Department of Primary Industries

OUT17/9276

Sunraysia Solar Farm (SSD 7680) Comment on the Environmental Impact Statement (EIS)

APPENDIX B SUNRAYSIA SOLAR INFRASTRUCTURE PLAN

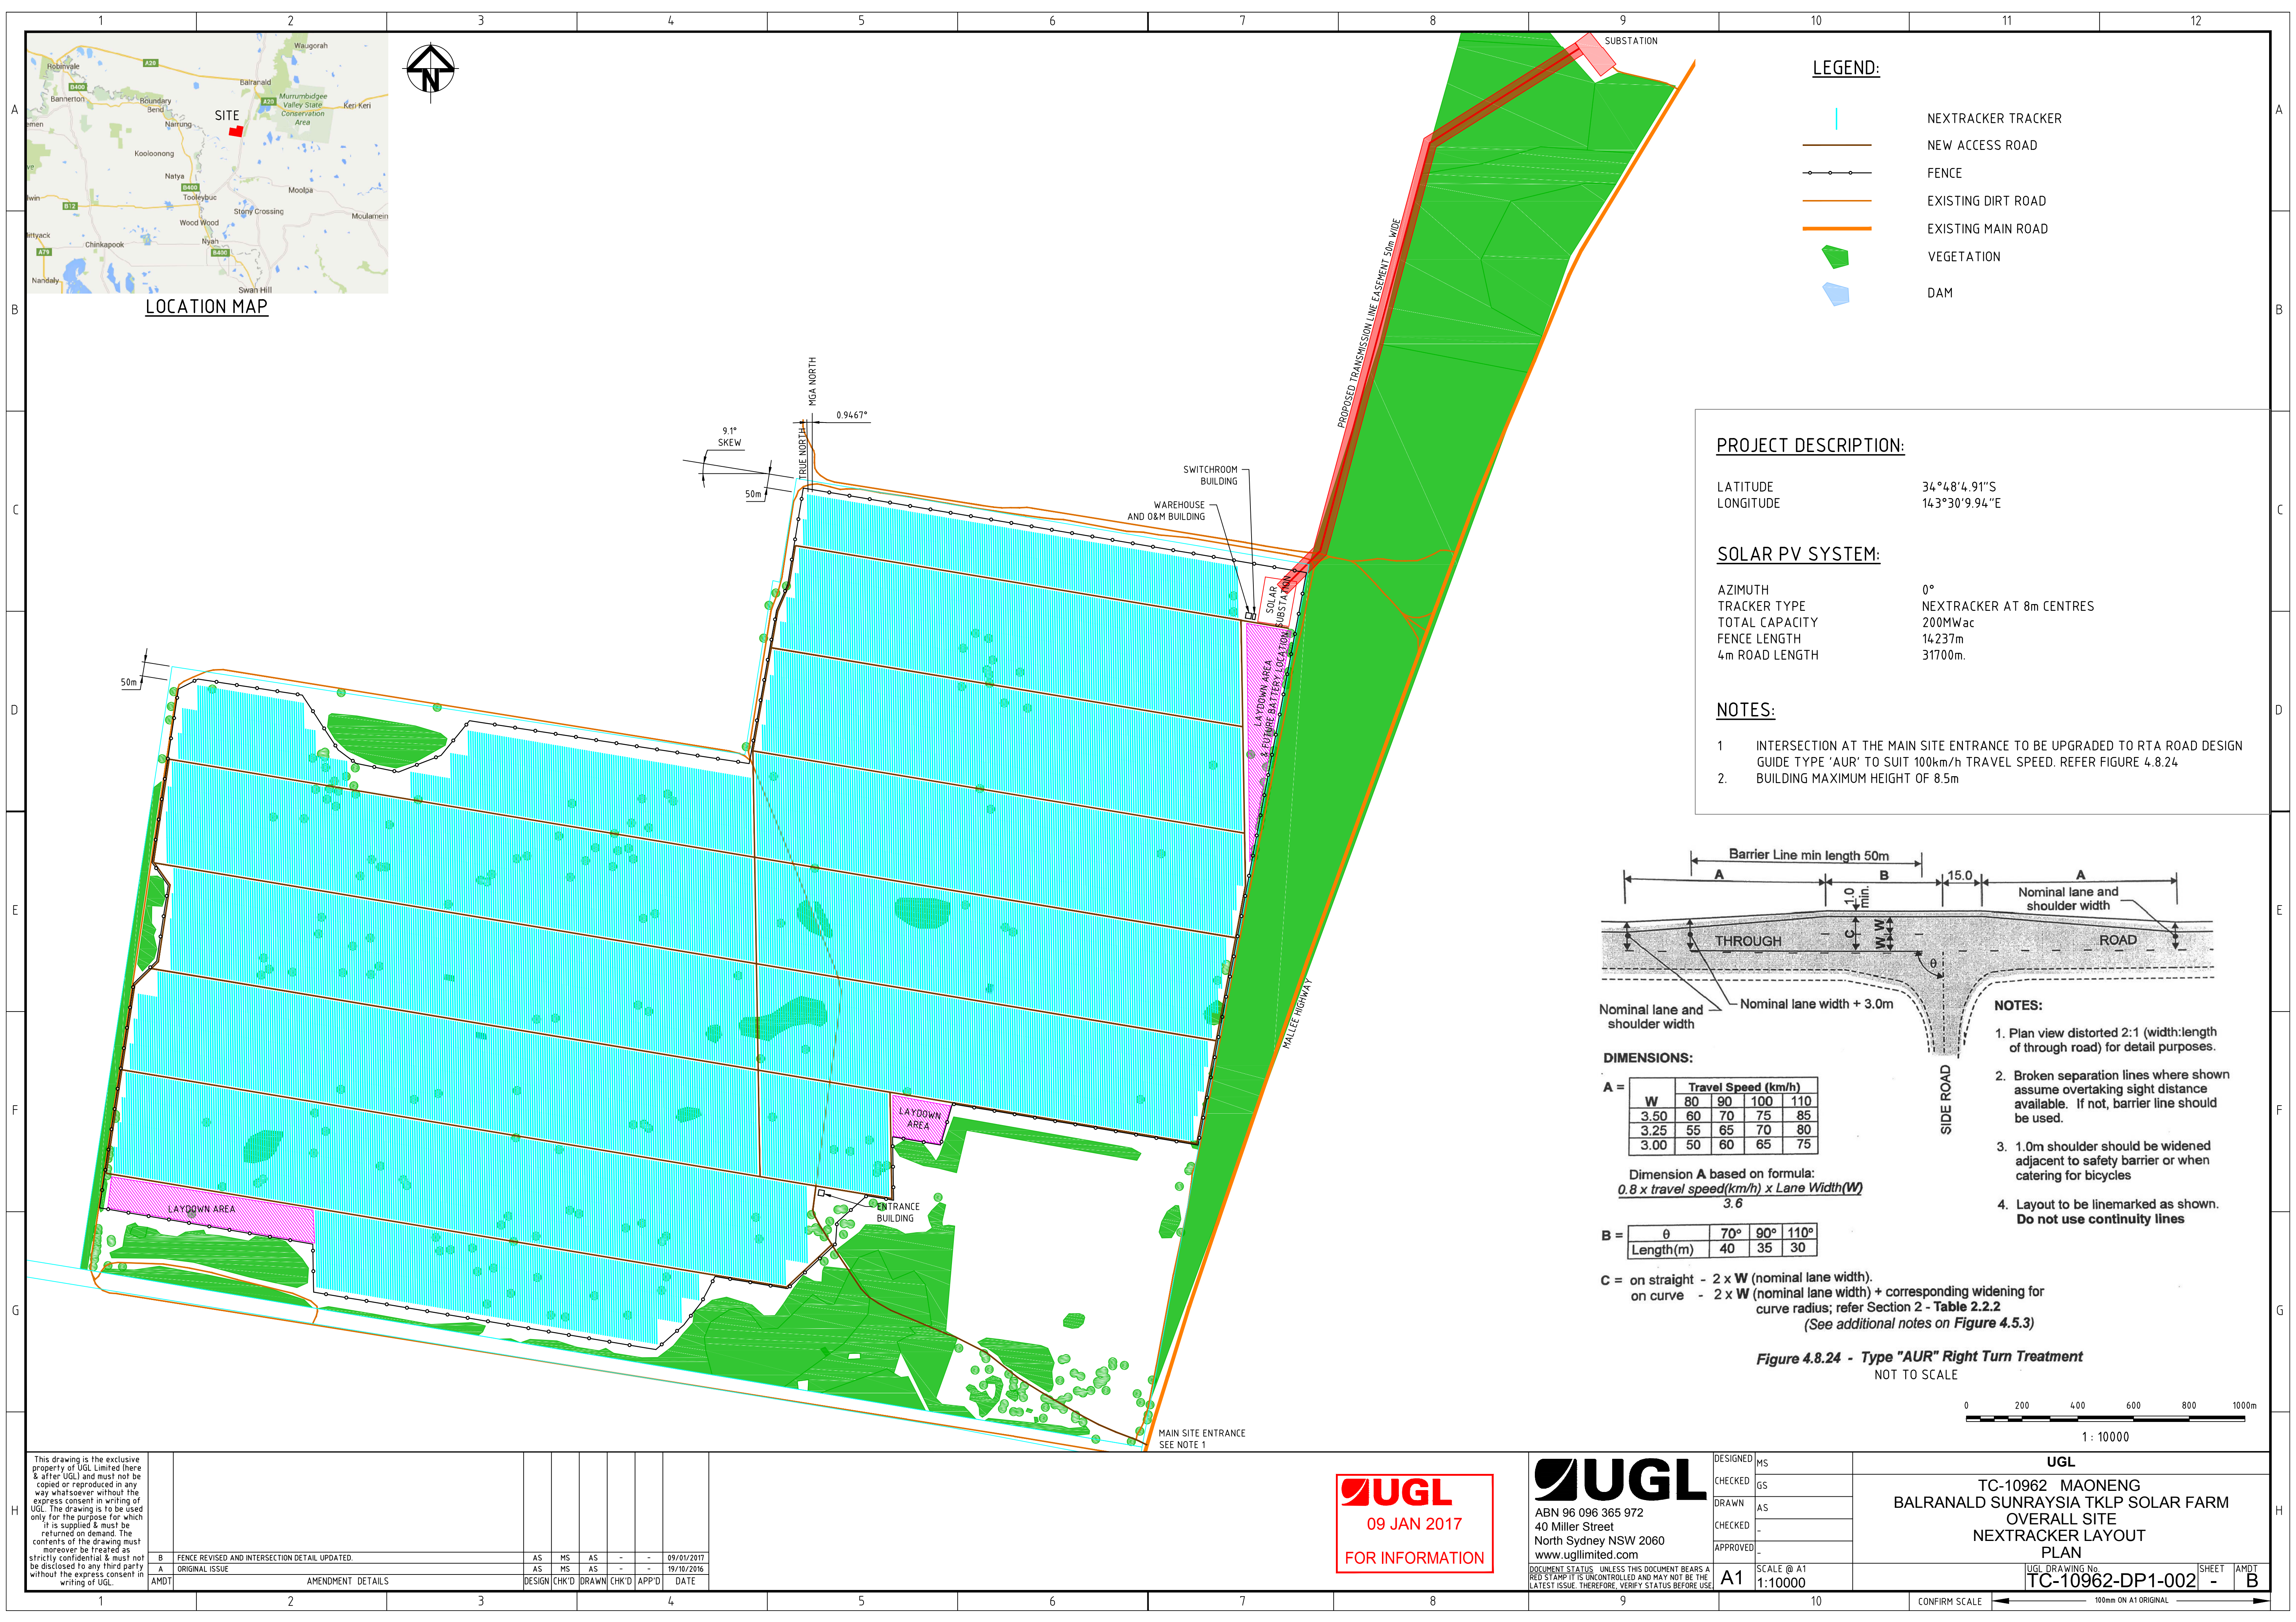
- The proponent should confirm whether 3 dams identified in the EIS within the footprint of the proposed solar arrays are to be removed. If so, an impact assessment should be undertaken.
